City of Albuquerque Stormwater Construction Site Inspection Report

ESC File No.	H10E033	Project Name:	2200 Vista Oriente		
NPDES Id. No.	NMR10036M	Location:	2200 Vista Oriente		
10/19/2023	Owner	Contractor			
Operator	Tuan Huynh				
Contact name & title	Tuan Huynh				
e-mail	tuanvhn@gmail.com				
Contact Phone #	505-269-1418				
COA Inspector	Chancellor English	Start/End Time:	1145am		
Construction Phase:	none, weeds and partial land disturbance				
Type of Inspection:	<input checked="" type="checkbox"/> Regular	<input type="checkbox"/> Storm Event	<input type="checkbox"/> Post Storm Event >0.25"	<input type="checkbox"/> 311/Complaint	<input type="checkbox"/> Follow Up
Weather at time of inspection?	Clear	Temperature:	~	75	
Estimated date of last storm 0.25" or greater	9/14/2023

TEMPORARY EROSION AND SEDIMENT CONTROL PLAN

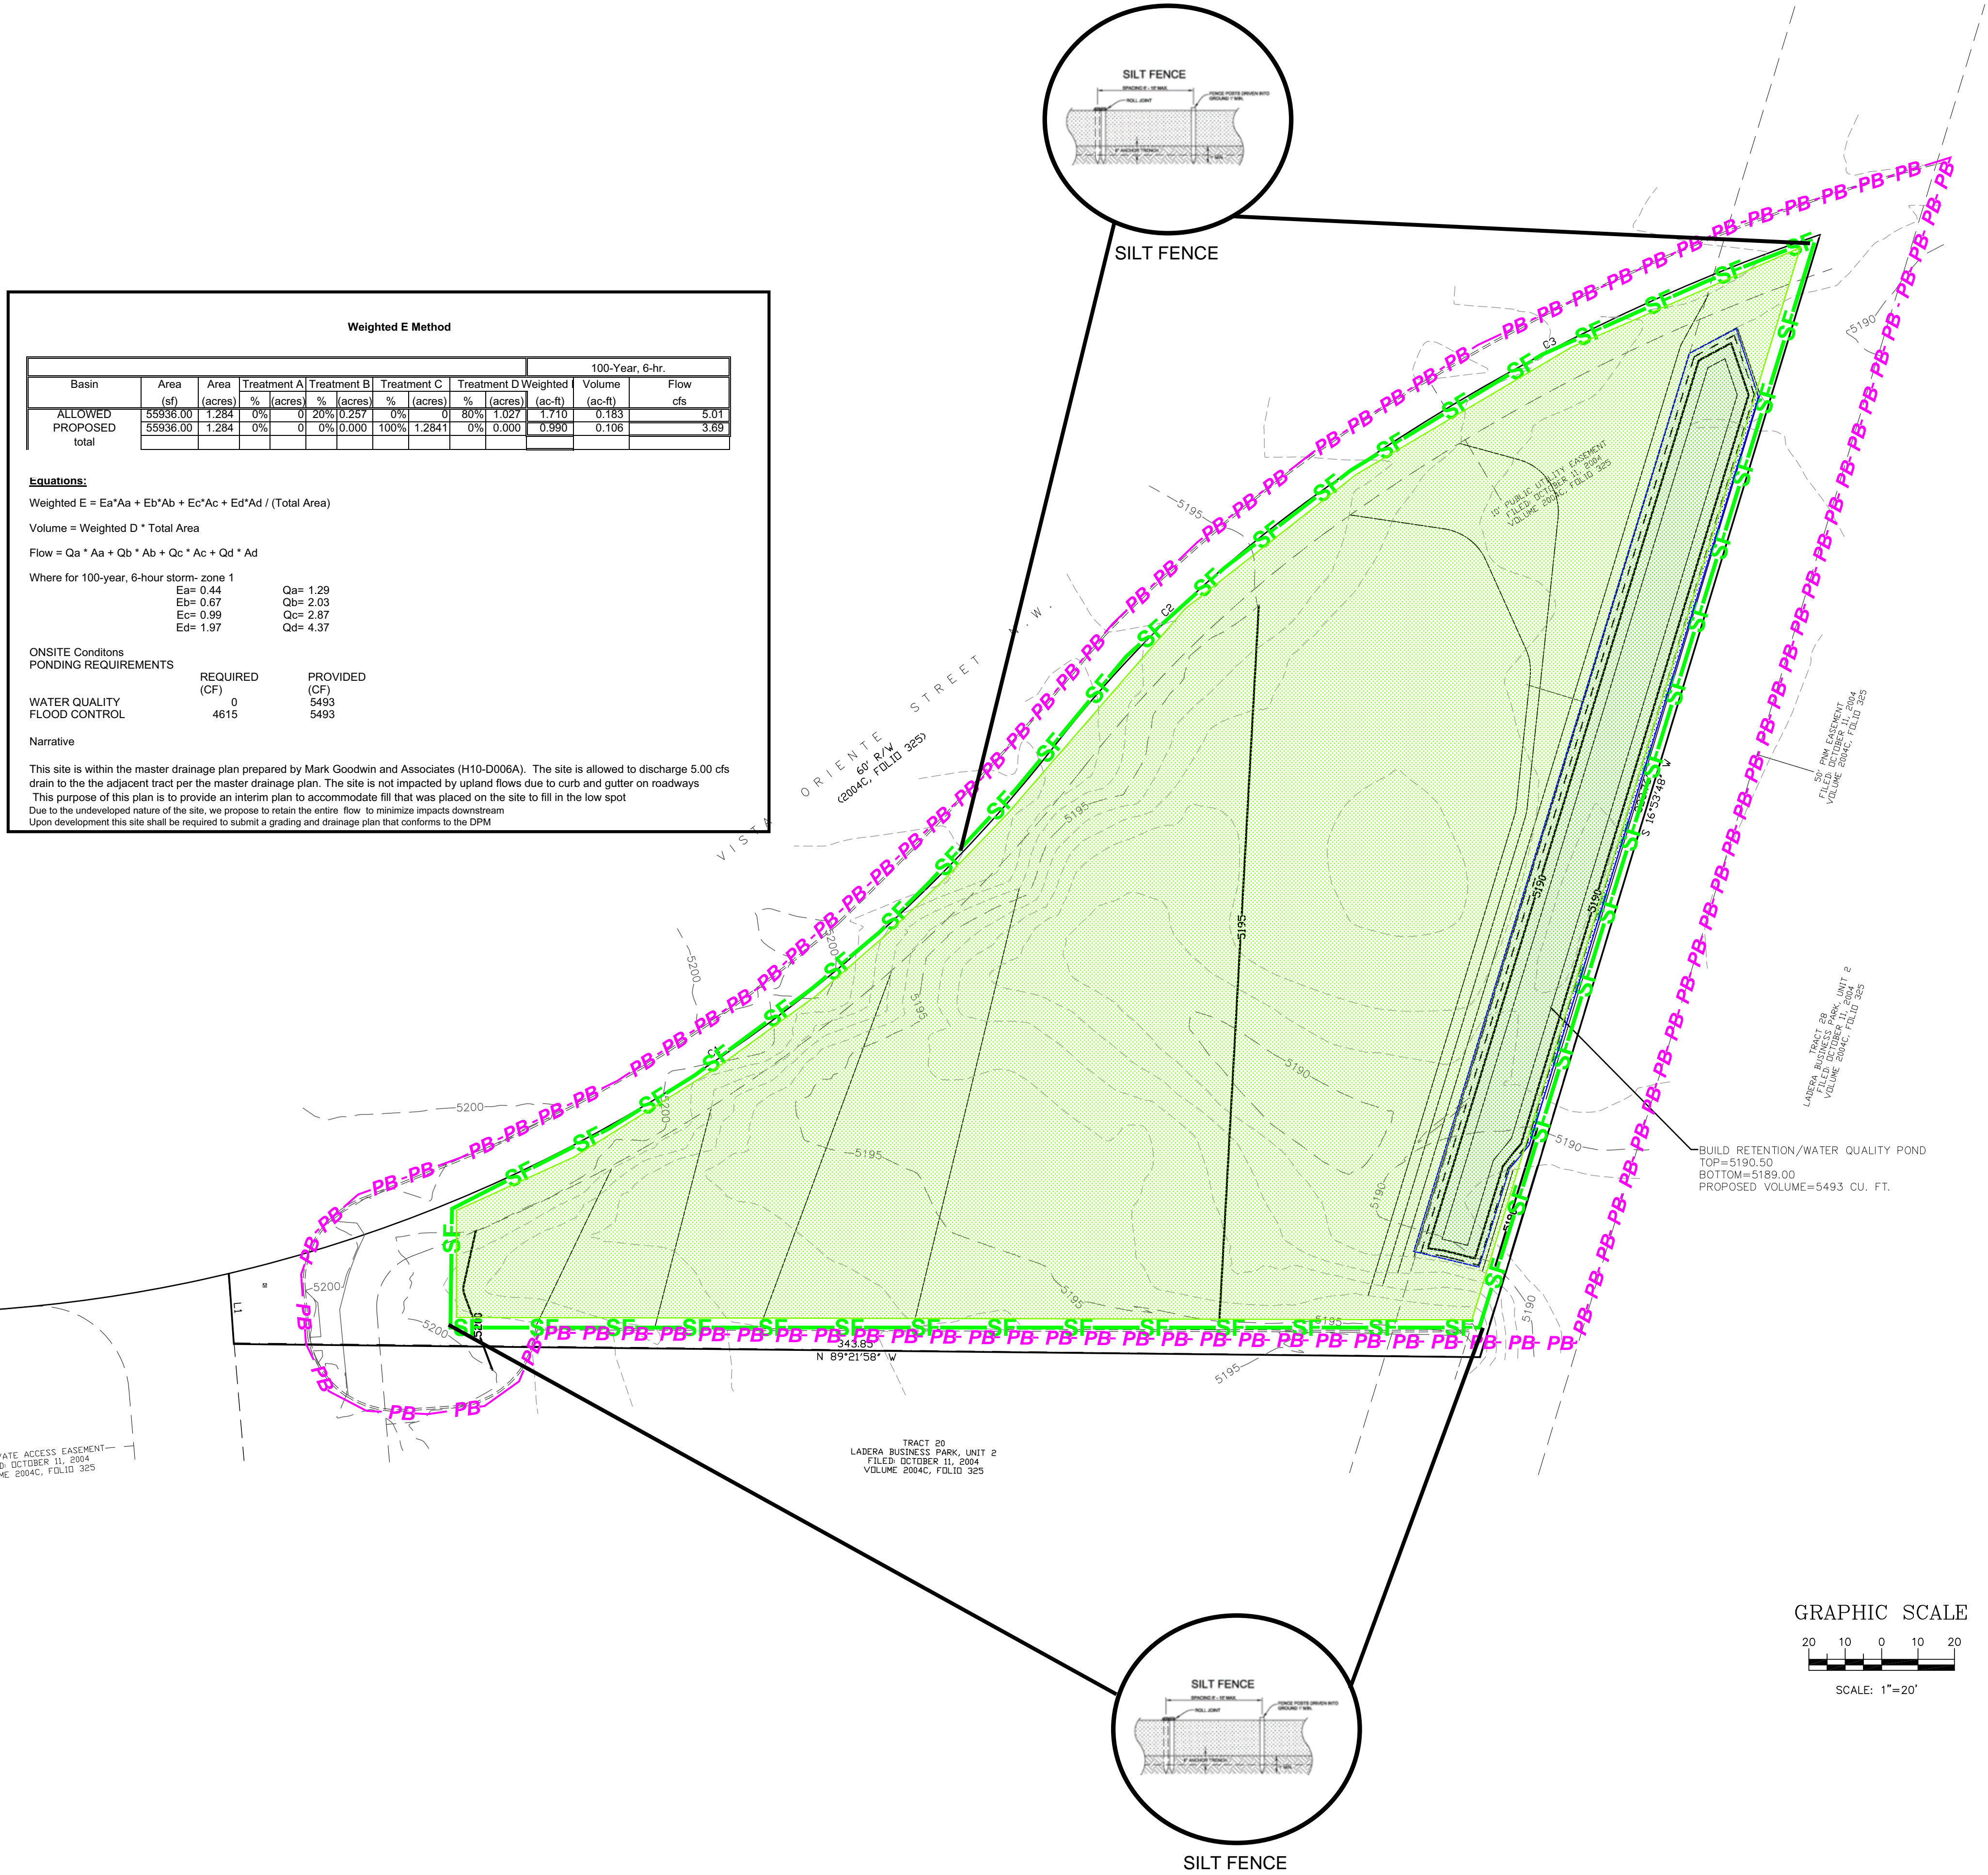
3	The perimeter silt fence has decayed and virtually non-existent in violation of CGP Part 2.1.4. Required mitigation: Ensure all stormwater controls are maintained and remain in effective operating condition during permit coverage per CGP Part 2.1.4.				
4	The site is still lacking compliant stabilization per CGP Part 2.2.14. The weeds are not sufficient vegetative cover and have become overgrown in violation of City Ordinance 9-8-4. The disturbed area needs stabilization. Required mitigation: Maintenance of weeds and stabilize the site if no construction activity for 14 or more calendar days as per CGP Part 2.2.14.
